From: Ian Stocks [REDACTED] **On Behalf Of** FRS Water and Access
Sent: 31 March 2022 08:14
To: Planning.Responses <Planning.Responses@arun.gov.uk>
Subject: RE: Planning Consultation on: AL/36/22/DOC

Application No: AL/36/22/DOC
Registered: 23rd March 2022
Site Address: Land At Wings Nursery Lidsey Road Woodgate PO20 3SU
Description of Works: Approval of details reserved by condition imposed under AL/20/21/PL relating to condition 22-details of required fire hydrants.

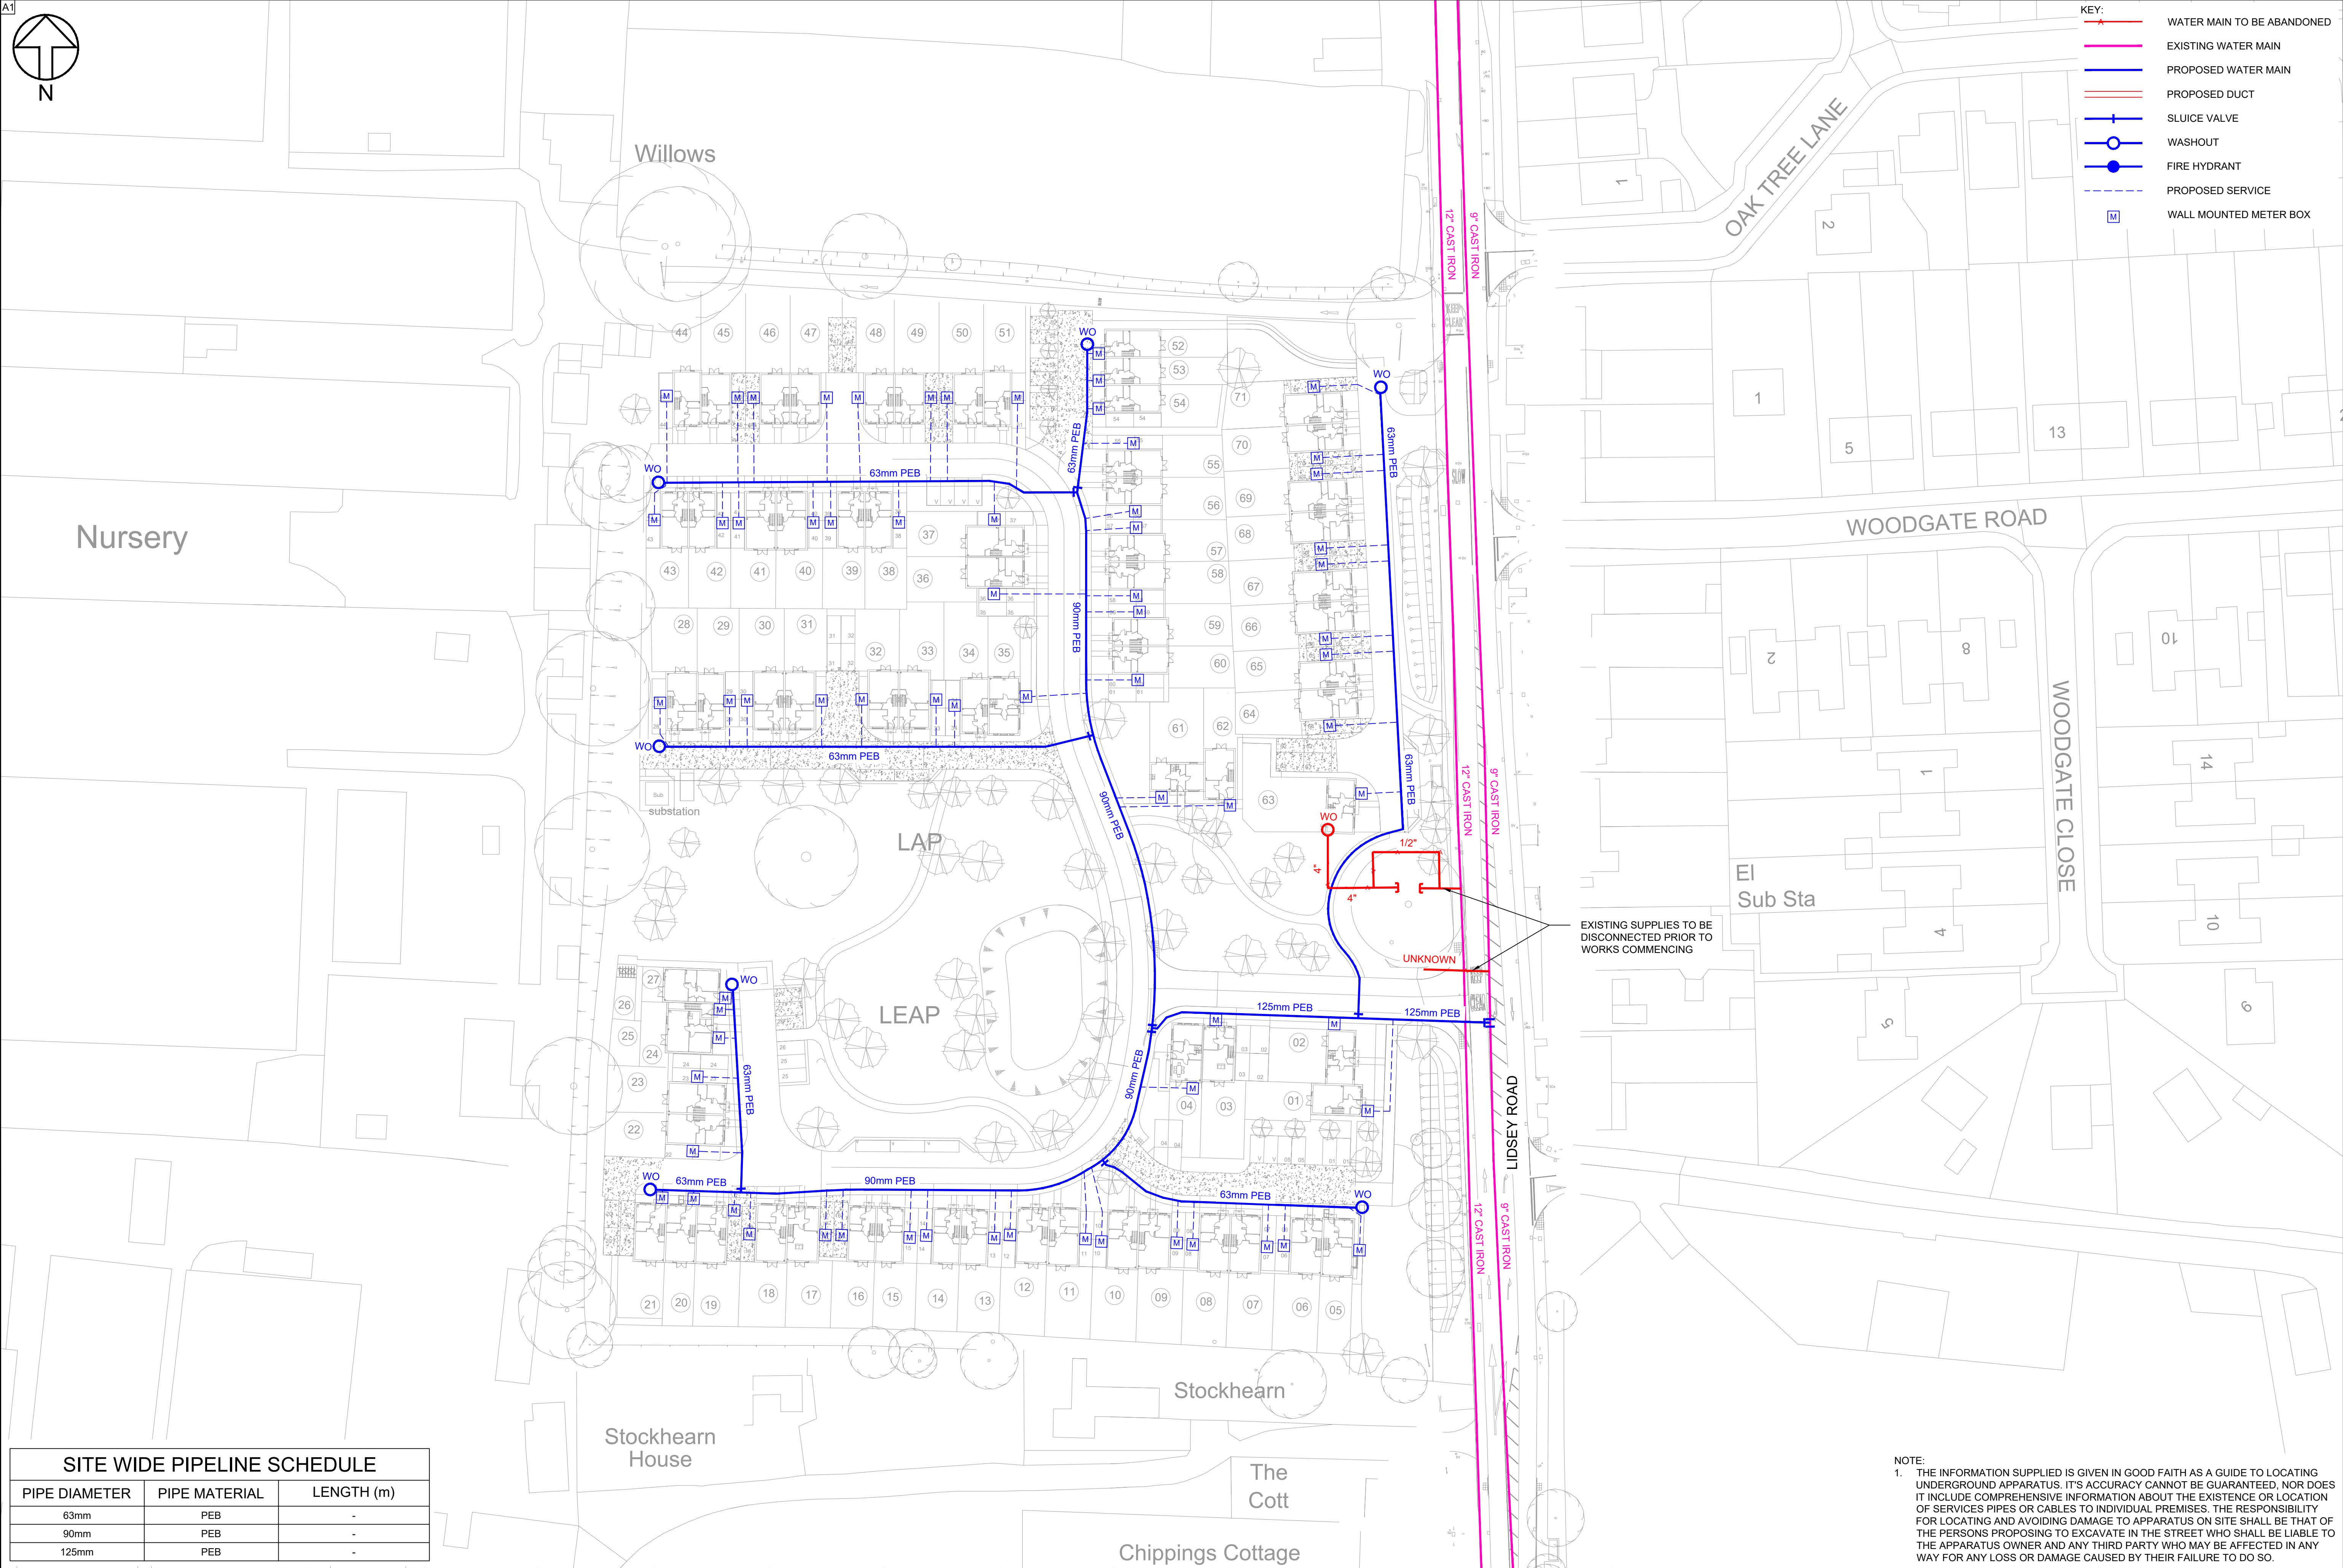
Having viewed the information submitted for the application to discharge the fire hydrant condition, the water main plan does not match the water main West Sussex Fire and Rescue Service agreed with Portsmouth Water. We consulted with Portsmouth Water on 26th November 2019 requesting 2 washout hydrants to be adopted as fire hydrants and one additional fire hydrant.

The water main plan submitted does not have any fire hydrants indicated and all the wash out hydrants are on 63mm mains. The minimum mains size for a fire hydrant is 90mm, so the mains indicated on the plan submitted is not suitable for supplying any fire hydrants, the mains size is too small.

Therefore the fire hydrant condition has not been met and should not be discharged.
